Notice of Modification

Section 75W of the *Environmental Planning and Assessment Act 1979*

The project approval (08_0101) granted by the Minister for Planning on 26 November 2010 for the Integra Underground Project.

APPENDIX 3: PROJECT LAYOUT PLANS

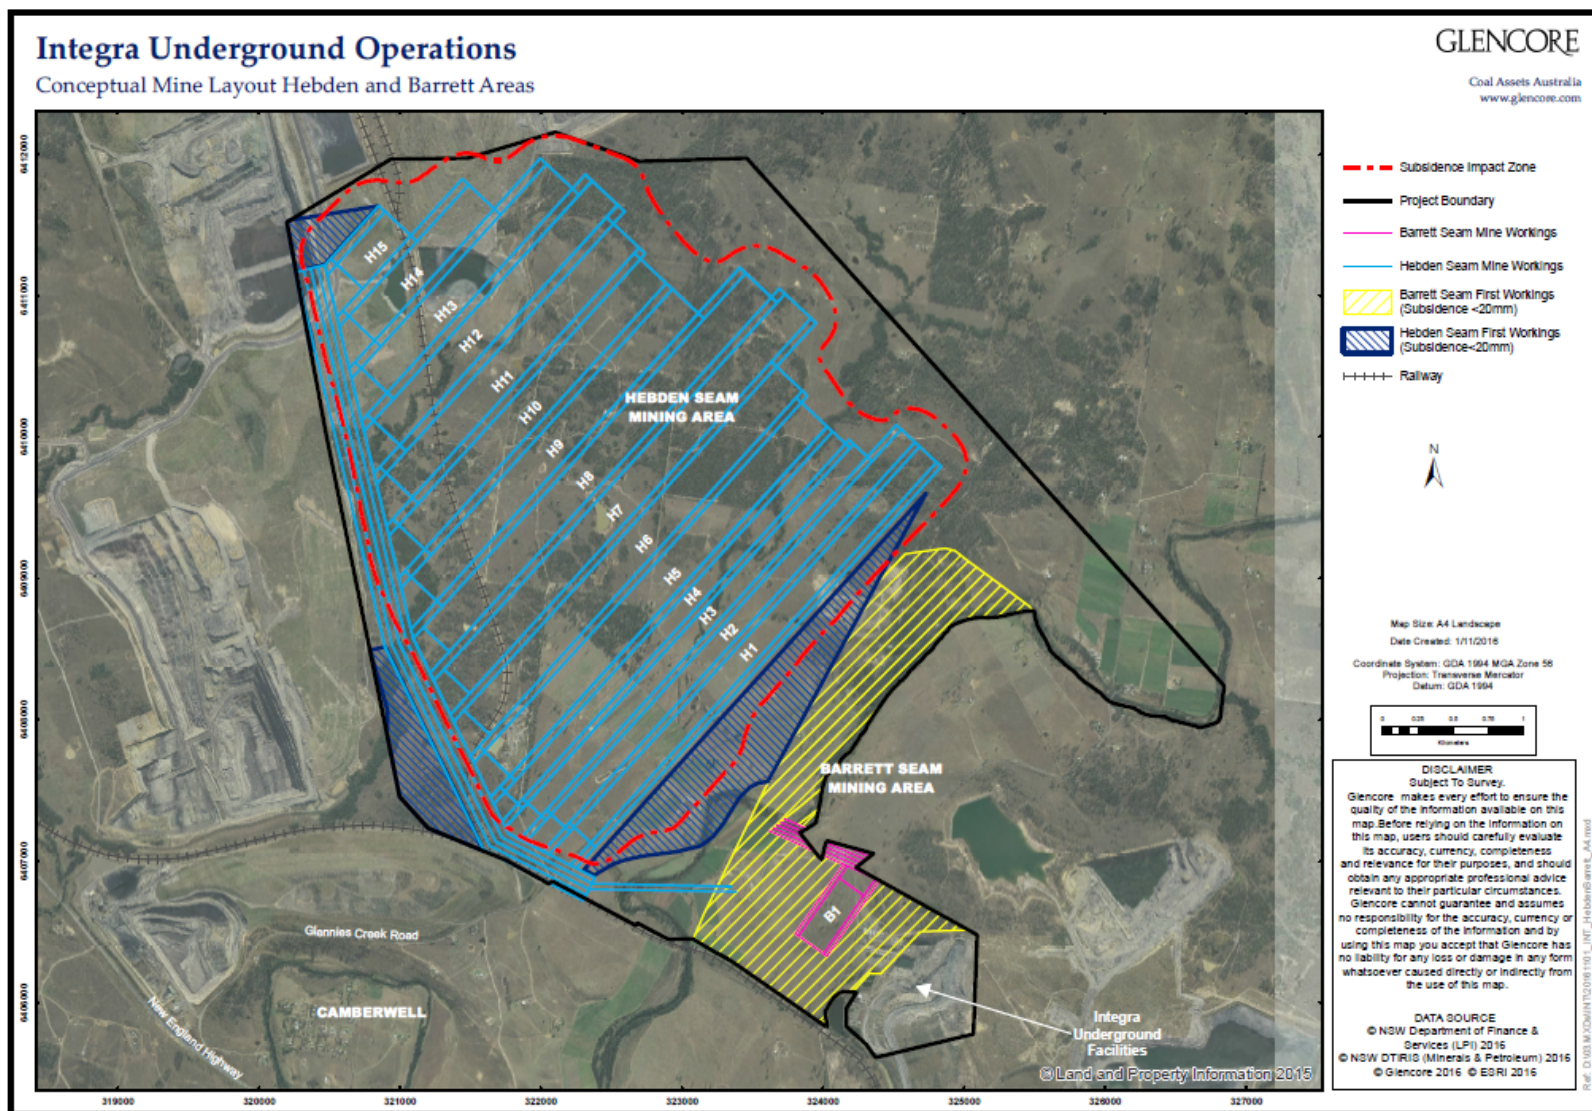
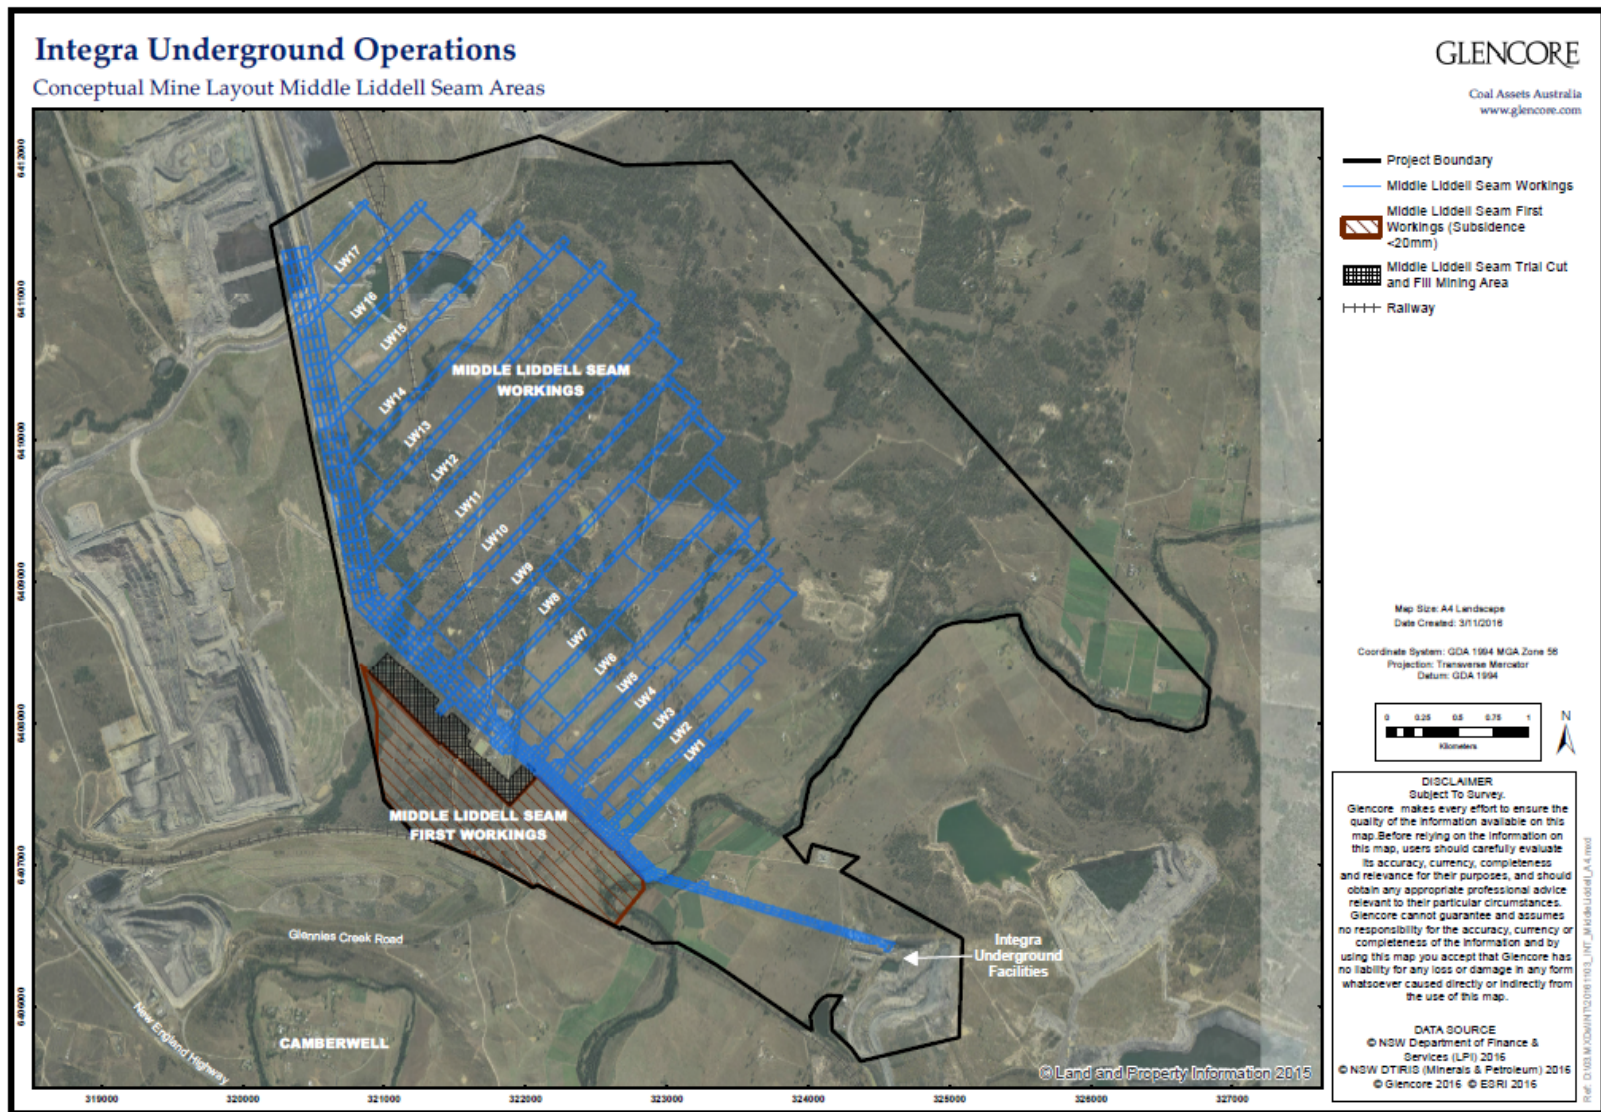
8. Delete Appendix 3 and replace with the following:

Hebden and Barrett Mine Seam Areas

Conceptual Mine Layout Middle Liddell Seam Areas

Middle Liddell Seam Areas
